Able Marine Energy Park

Material Change 2

Statement of Common Ground

ENVIRONMENT AGENCY

Figure 8-10: Predicted significant wave height for the selected offshore condition, MHWS, existing present-day bathymetry (GoogleEarth imagery)

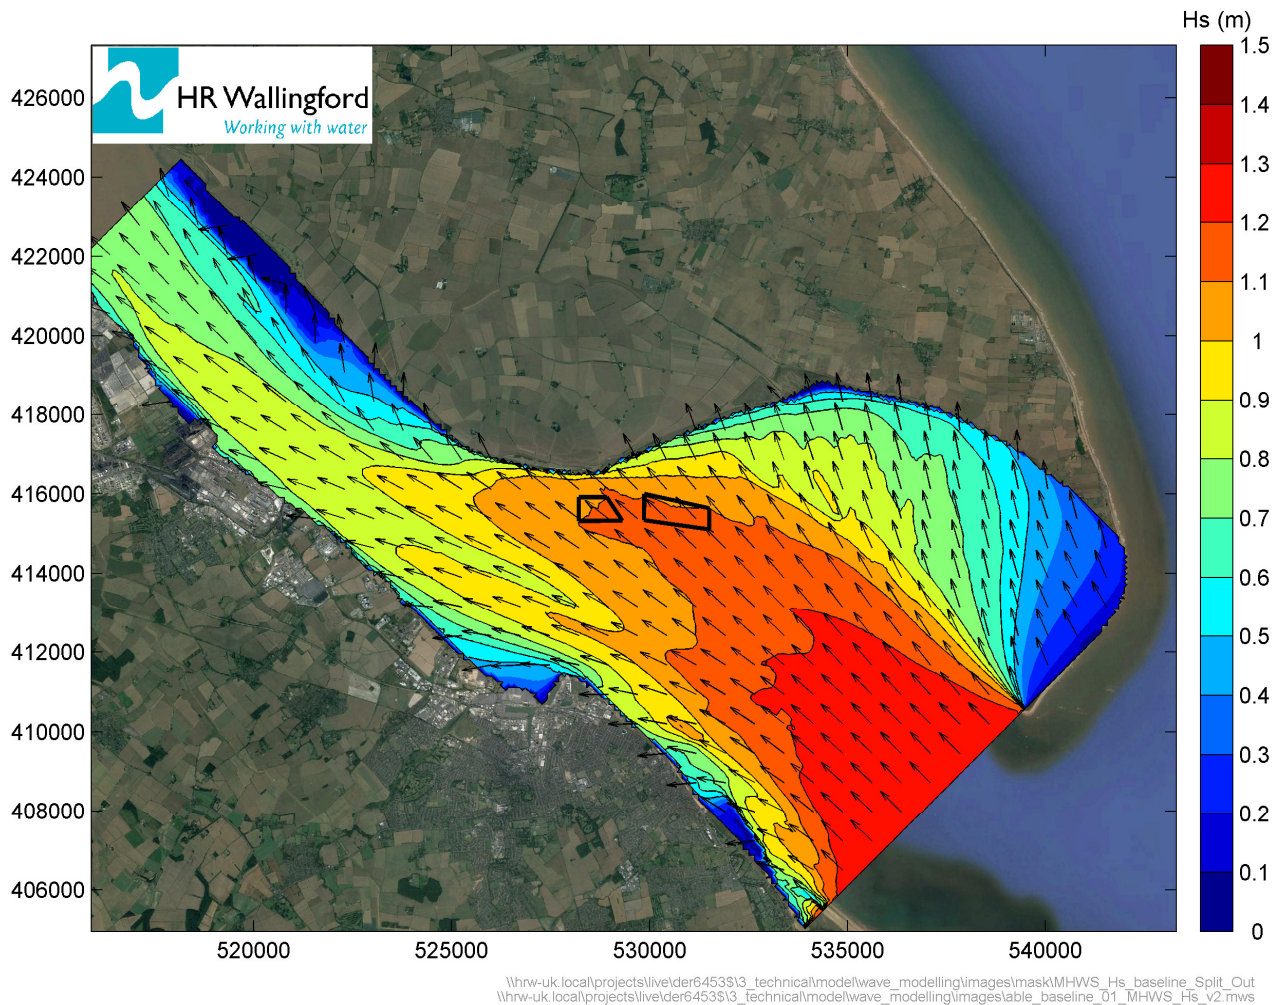
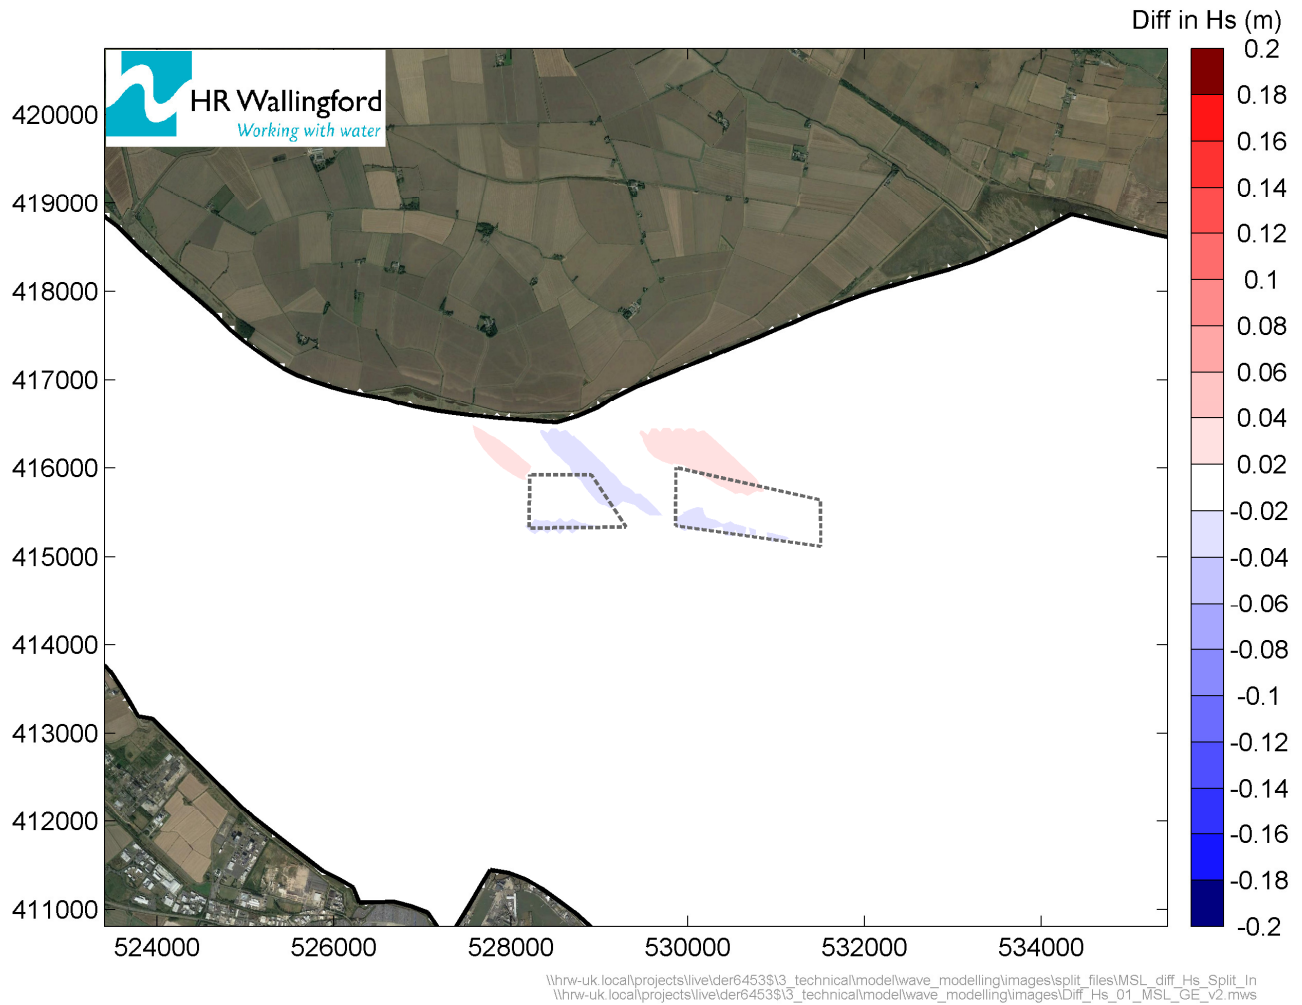
| Comment by | Para. | Comment | ES Ch 8 Section (if noted) | HR Wallingford response |
|--------------------|-------|---|----------------------------|--|
| Environment Agency | 4.1 | <p>Impact of changes to hydrodynamics on Hawkins Point (Section 8.4.36 onwards):</p> <p>One wave condition was chosen to carry out this assessment, but it is not clear why this particular condition, and only one, was chosen. We, therefore, request more clarity on this in order to provide confidence in the conclusions reached.</p> | 8.4.36 onwards | <p>The nearshore wave rose for Hawkins Point (from The Humber Tidal Database and Joint Probability Analysis of Large Waves and High Water Levels Annex II, ABPmer (2007) report for the Environment Agency) is shown below.</p> <p style="text-align: center;">Wave rose for Hawkins Point</p> |

In line with the original ES submission, to assess the potential changes to waves resulting from disposal activities (now at both HU081 and HU082), waves entering through the mouth of the estuary were selected. The value selected was Hs 1m, Tm-10 = 4s, and direction 135 degrees was considered appropriate to capture the effects on larger waves (which will “feel” the seabed at deeper depths than smaller waves) of the disposal mounds. In terms of why other directions were not selected, it is seen from the table and wave rose above that a) 60% of all wave energy (including much smaller waves) is predicted to be incident from between 110 and 150 degrees, and b) almost all waves of Hs = 1m and above are incident from this direction.

This single wave direction of 135 degrees was therefore representative of these incident waves. Importantly, the waves were also modelled for three different water depths (as per the original ES). For these larger Hs = 1m waves from 135 degrees, the predicted changes to wave height are negligible for MHWS, approximately +/-2cm for MSL, and approximately +/-5cm for MLWS.

Impact of changes to hydrodynamics on Hawkins Point

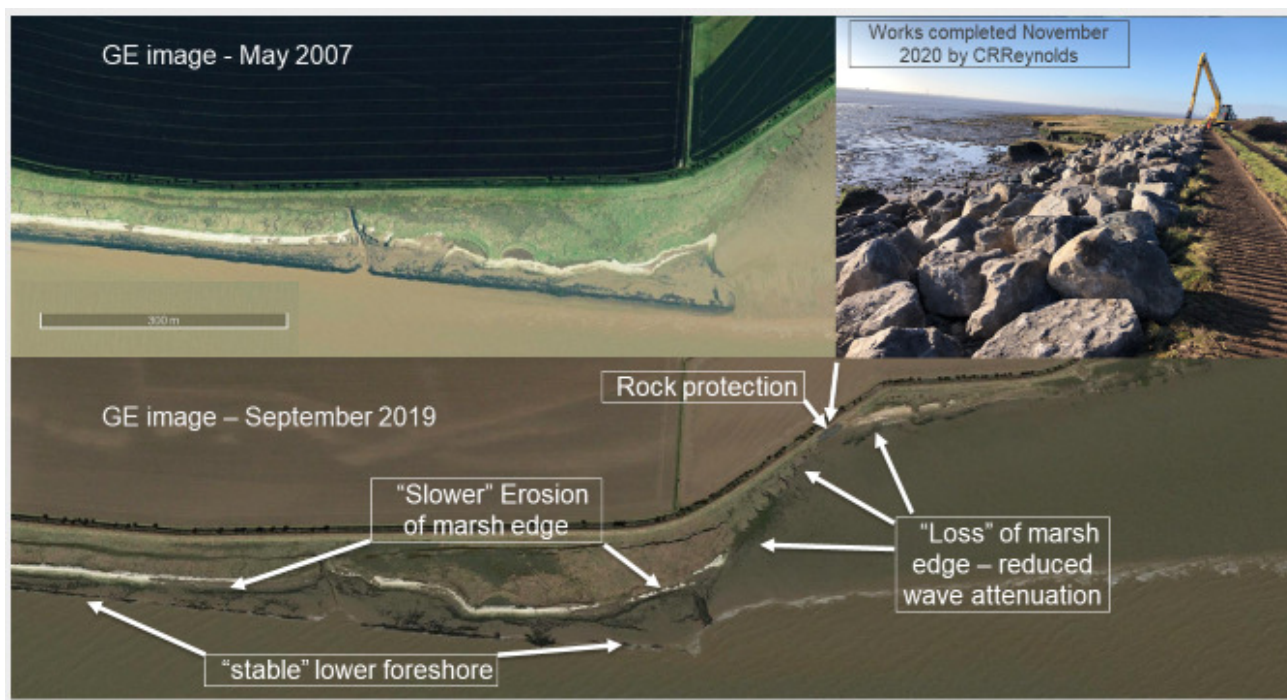
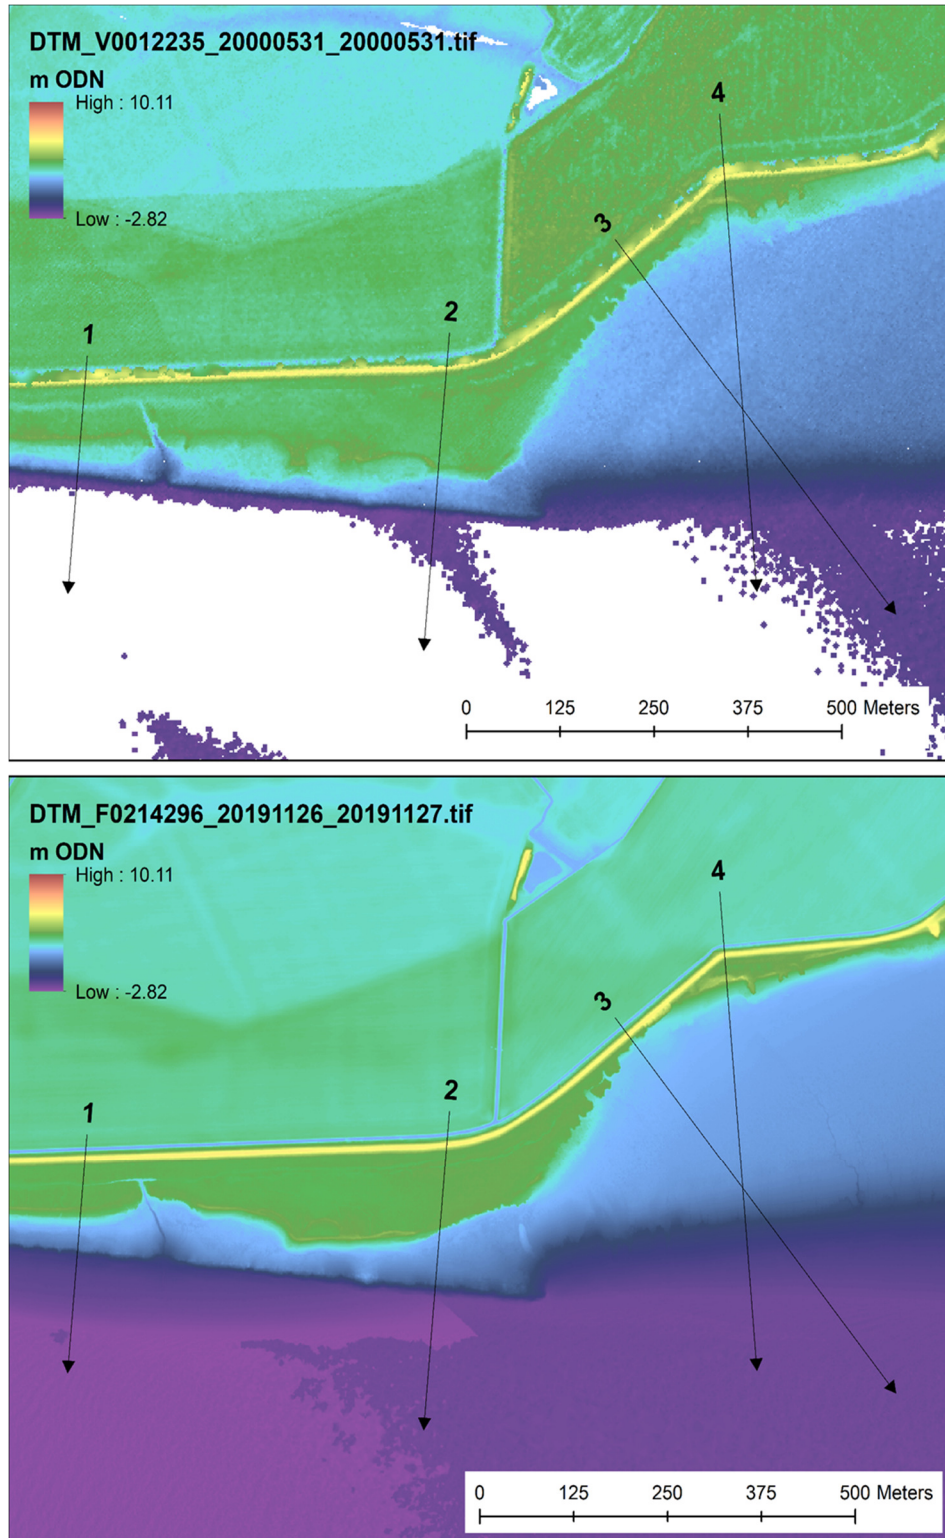
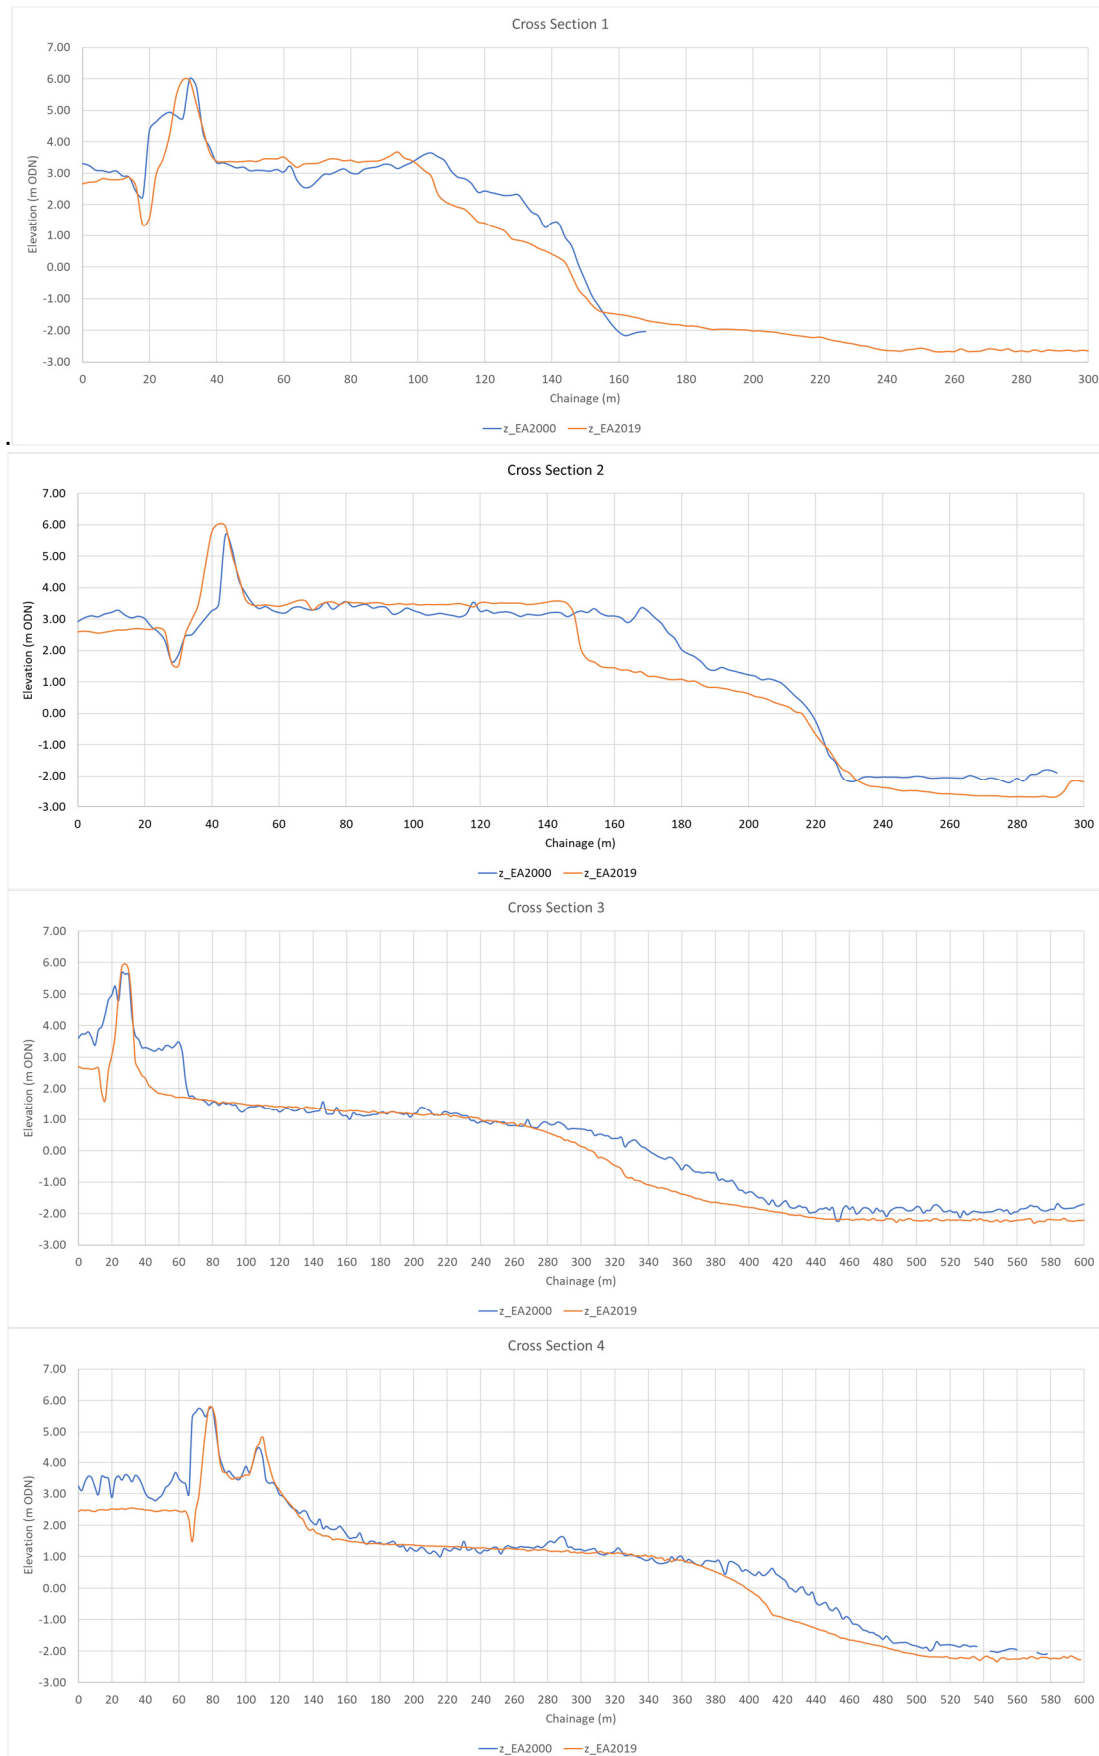
| | 4.3 | <p>If these points can be clarified, the conclusion that there is limited impact on the currently eroding section seems reasonable. However, this assessment does also indicate some increasing wave activity which could result in foreshore erosion to the west of Hawkins Point (8.4.39). Whilst this section of the foreshore is currently stable, the potential impact here needs some further consideration in regards to risk to habitat/flood defences.</p> | | <p>For a combination of high waves with a high sea level there is negligible change to the wave heights and therefore likely a negligible effect on flood risk. For lower sea levels, changes to wave heights, as noted above, are +/- 2cm at MSL and +/-5cm at MLWS.</p> <p>It is worth noting that these impacts relate to the two disposal sites conservatively being assumed to be filled to the -5.3mCD limit, when in reality it is expected that the post-construction level will be lower than this.</p> <p>The predicted changes to waves are within the natural variability of incident wave conditions. The predicted changes are transient (they will diminish with the dispersion of disposed material from HU081 and HU082) and are expected to last for a few years.</p> <p>Overall, for the above reasons, there is considered to be no increase to flood risk.</p> <p>Analysis of historic change of profiles derived from LiDAR data running across the low intertidal up to the elevation of marsh level have shown that to the west of Hawkins Point the lower intertidal of the foreshore is relatively stable, unlike that to the east of Hawkins Point. Whilst it is recognised that at MLWS and MSL there are small increases in wave heights (see above) it is not considered that such small increases will lead to significant erosion of the lower foreshore which appears currently to be stable. The increases are likely to be insignificant within the natural variability of the incident wave conditions.</p> <p>If this foreshore were presently subject to erosion a small increase in such erosion might be anticipated for the few years that it will take for the glacial clay to disperse from the disposal sites. However, given the relative stability of the lower foreshore to the west of Hawkins Point, it is unlikely that the small predicted increase in wave height at lower water levels will be sufficient to instigate a trend for erosion.</p> |

Selected wave condition is the same as was selected in EXB.7A (Hs 1m, Tm-10 4s, Dir 135 degrees - MSL, MHWS, MLWS)
 60% of all wave energy is incident from 110 to 150 degrees
 99.7% of wave energy for waves of Hs = 1m or higher is from 110
